RESPONSE STATEMENT TO THE MT ARTHUR COAL OPEN CUT MODIFICATION LANDSCAPE & VISUAL IMPACT ASSESSMENT REPORT

MICHAEL WRIGHT
REGISTERED LANDSCAPE ARCHITECT

FOR
DARLEY

MAY 2013

FIGURE 4 – VIEWPOINT LOCATIONS

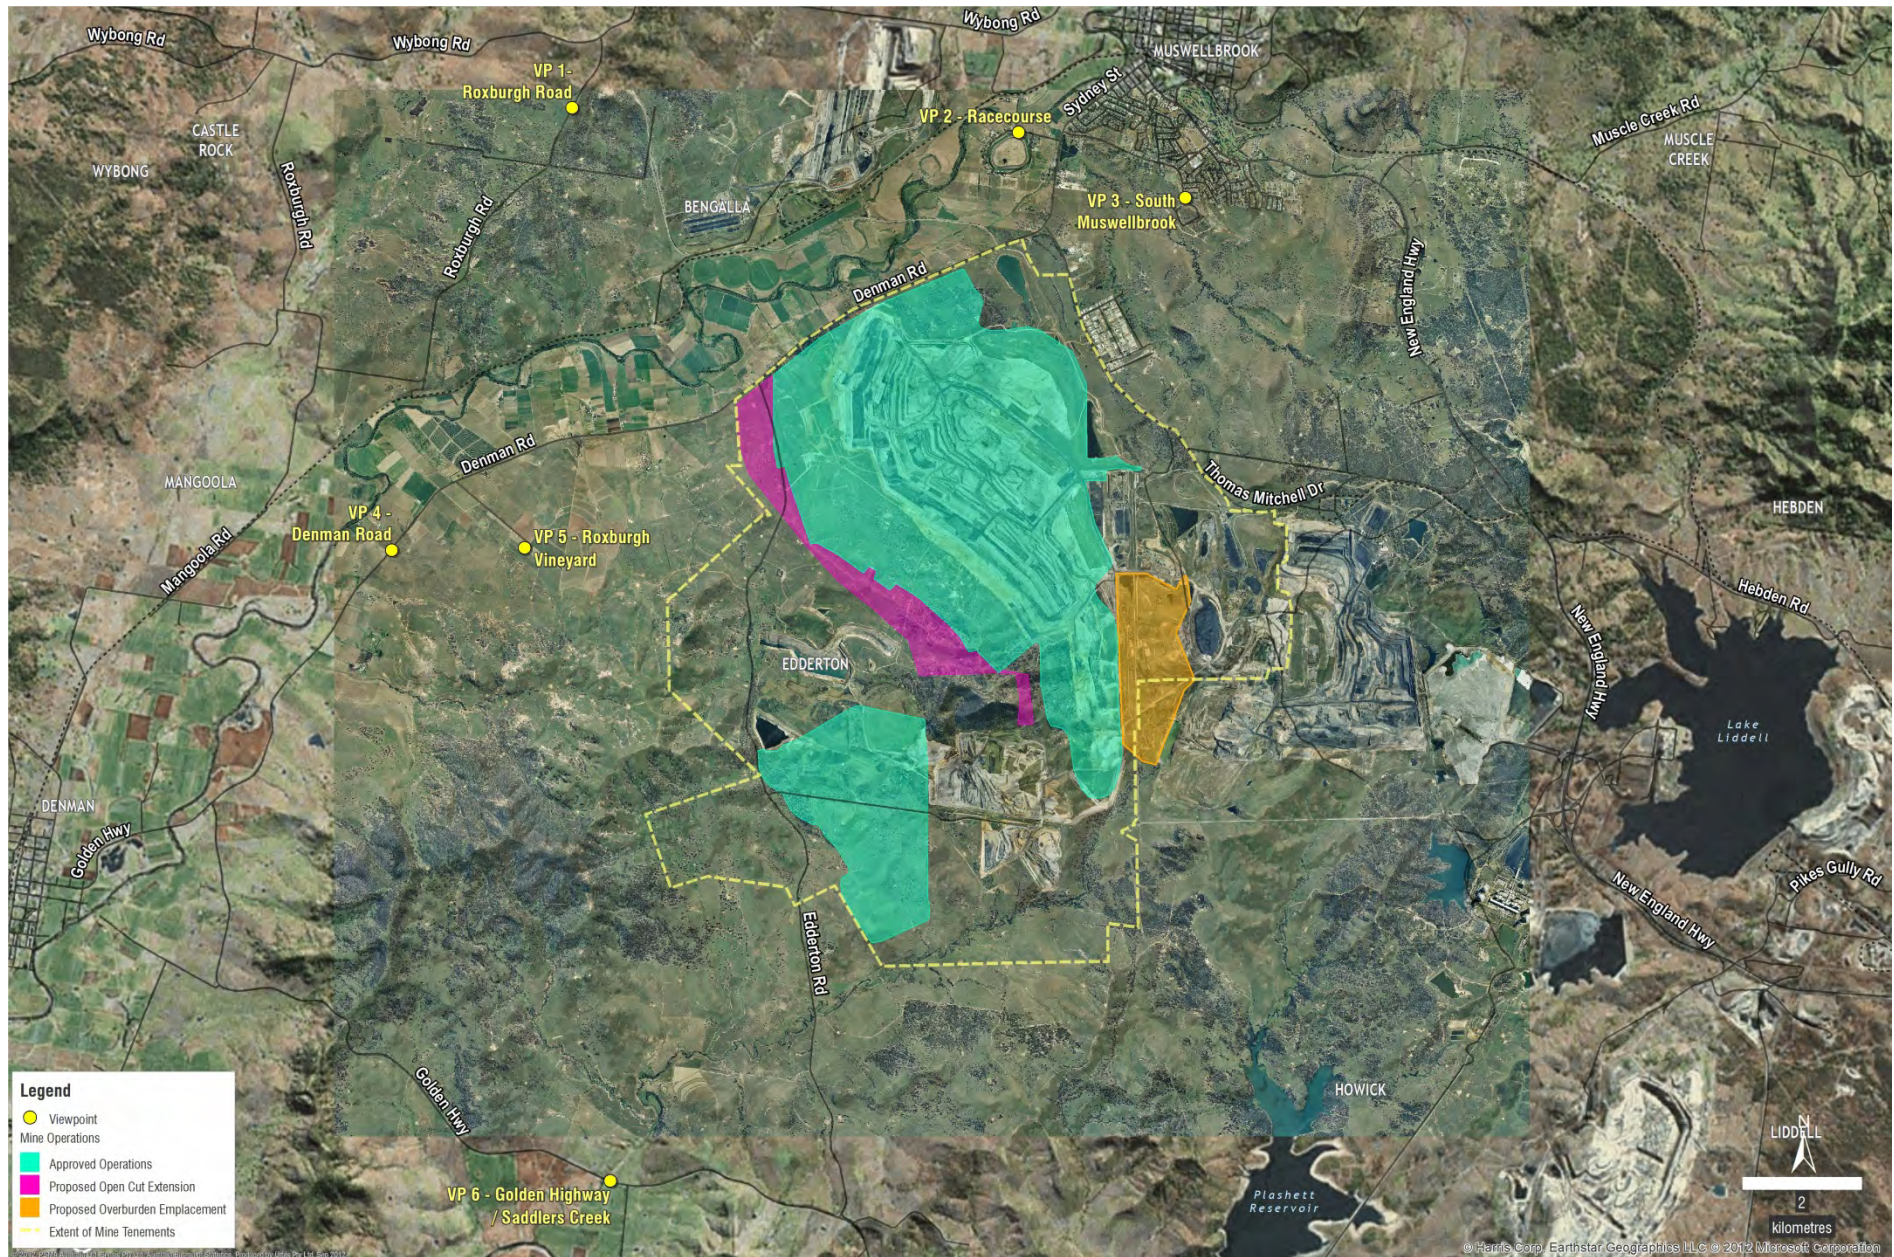
2. Figures 4 & 5 need to be checked against the correct open cut mine footprint to confirm that they are accurately depicting the area of open cut east of Mt Arthur and if they are not correct, the figures must be corrected and the visual impact assessment needs to be reassessed to take this new footprint into account.

Figure 4 on page 19 and Figure 5 on page 23 depict viewpoint locations and the predicted visual catchment of the existing mine and the proposed Modification, respectively, however there appears to be an inconsistency between these two figures and the previous figure (Figure 3 on page 11). The purple area indicated as Proposed Open Cut Extension in Figure 4 and 5 to the immediate east of Mt Arthur, is represented with a smaller footprint than the same area in Figure 3. This could be an issue if the open cut area is larger than depicted on the two figures (4 & 5) as it could increase the amount of exposure and therefore visual impact of the Modification on areas south and east of Mt Arthur. This apparent inconsistency needs to be addressed and if Figures 4 & 5 are incorrect, then the visual impact assessment needs to be reworked to reflect this change.
